# Tween Bridge Solar Farm

## 8.13 Change Request Environmental Statement Addendum

Document Reference: 8.13

## Change Request – Environmental Statement Addendum

Drawing Ref: Environmental Statement Volume 4, Figure 2.2a: Indicative Operational Layout Plan

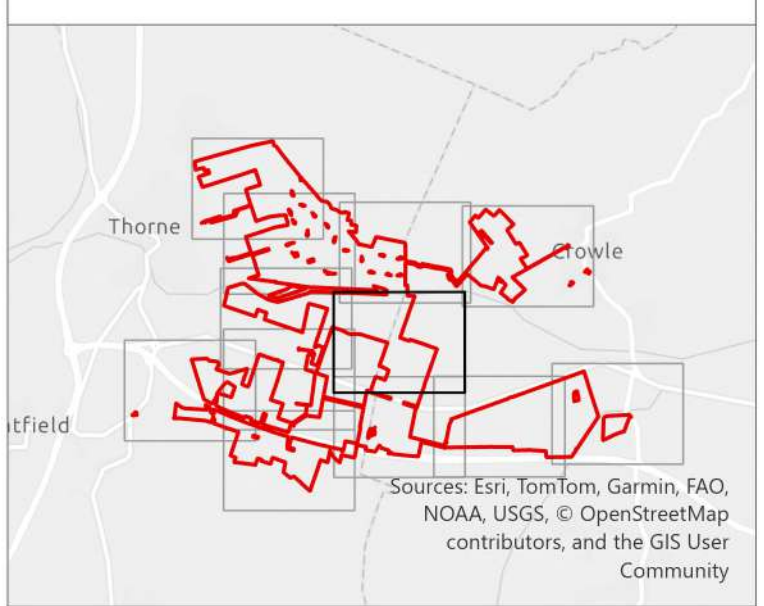
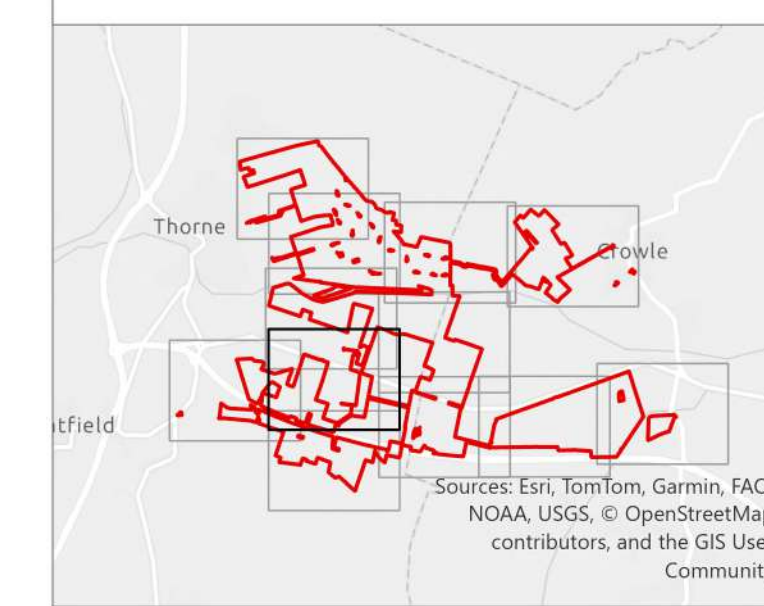
Document Reference	Reason for Amendment	ES Amendment at Deadline 1 (May 2026)
ES Volume 4 Figure 2.2a Indicative Operational Layout Plan (Fixed Solar Panels) [Document	Not updating in ES addendum <b>Figure 2.2a Indicative Operational Layout Plan (Fixed Solar Panels) [Document Reference 6.4.2.2a Revision 2]</b> are reissued to show the proposed revised route of the	ES Figure 2.2a <b>[Document Reference 6.4.2.2a Revision 2]</b> is amended to show the realignment of the indicative route of the proposed permissive path within mitigation area M1(A). The route has been realigned to ensure that the permissive path does not encroach upon the Special Category Land: Common

<p><b>Reference 6.4.2.2a Revision 2]</b></p>	<p>Permissive Path in mitigation area M1(A).</p>	<p>Land/Countryside and Rights of Way Act 2000 access land to the north of mitigation area M1(A). The remaining extent of the route would also be fenced with wooden pole and wire fencing.</p> <p>Resubmitted on 4<sup>th</sup> June 2026 as: <b>ES Volume 4 Figure 2.2a Indicative Operational Layout Plan (Fixed Solar Panels) [Document Reference 6.4.2.2a Revision 2]</b></p>
<p><b>ES Volume 4 Figure 2.2b Indicative Operational Layout Plan (Fixed and Tracker Solar Panels) [Document Reference 6.4.2.2b Revision 2]</b></p>	<p>Not updating in ES addendum.</p> <p><b>Figure 2.2b Indicative Operational Layout Plan (Fixed &amp; Tracker Solar Panels) [Document Reference 6.4.2.2b Revision 2]</b> is reissued to show the proposed revised route of the Permissive Path in mitigation area M1(A).</p>	<p>ES Figure 2.2b <b>[Document Reference 6.4.2.2b Revision 2]</b> is amended to show is amended to show the realignment of the indicative route of the proposed permissive path within mitigation area M1(A). The route has been realigned to ensure that the permissive path does not encroach upon the Special Category Land: Common Land/Countryside and Rights of Way Act 2000 access land to the north of mitigation area M1(A). The remaining extent of the route would also be fenced with wooden pole and wire fencing.</p>

Drawing Ref: Environmental Statement Volume 4, Figure 2.2a: Indicative Operational Layout Plan

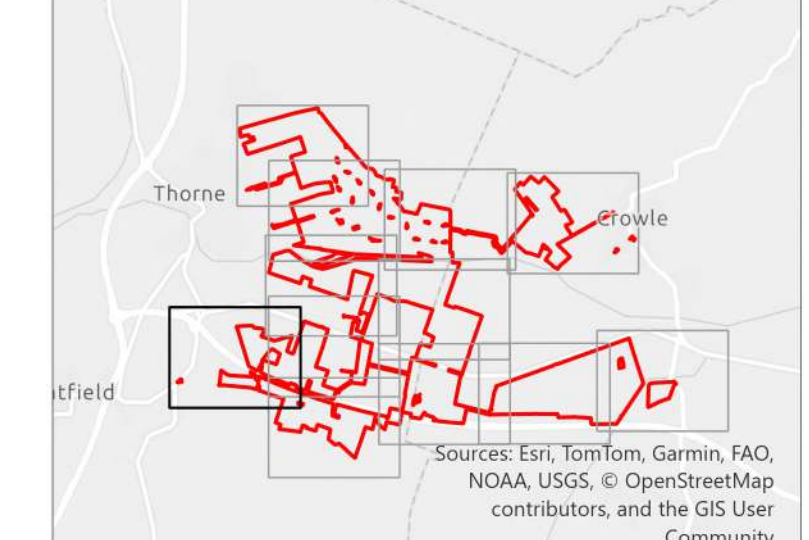
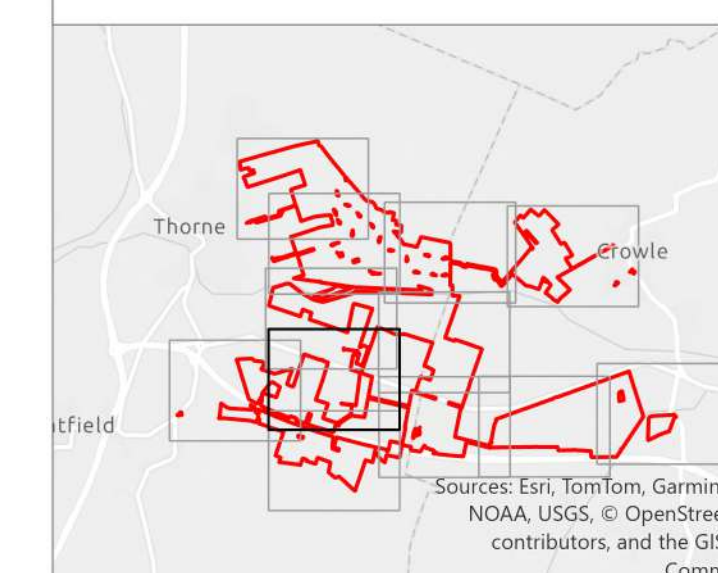
<p>Resubmitted on 4<sup>th</sup> June 2026 as: <b>ES Volume 4 Figure 2.2b Indicative Operational Layout Plan (Fixed and Tracker Solar Panels) [Document Reference 6.4.2.2b Revision 2]</b></p>
<p><b>ES Volume 4 Figure 6.4 Landscape and Visual Mitigation Strategy [Document Reference 6.4.6.4 Revision 3]</b></p>	<p>Not updating in ES addendum.</p> <p><b>Environmental Statement Figure 6.4 Landscape and Visual Mitigation Strategy [Document Reference 6.4.6.4 Revision 3]</b> is reissued to show the proposed revised route of the Permissive Path in mitigation area M1(A).</p>	<p>Environmental Statement Figure 6.4 <b>Landscape and Visual Mitigation Strategy [Document Reference 6.4.6.4 Revision 3]</b> is amended to show the realignment of the indicative route of the proposed permissive path within mitigation area M1(A). The route has been realigned to ensure that the permissive path does not encroach upon the Special Category Land: Common Land/Countryside and Rights of Way Act 2000 access land to the north of M1(A). The remaining extent of the route would also be fenced with wooden pole and wire fencing reaching a maximum height of 1.2m.</p> <p>The whole of the area within M1(A) within <b>Environmental Statement Figure 6.4 Landscape and Visual Mitigation Strategy [Document Reference 6.4.6.4 Revision 3]</b> will</p>
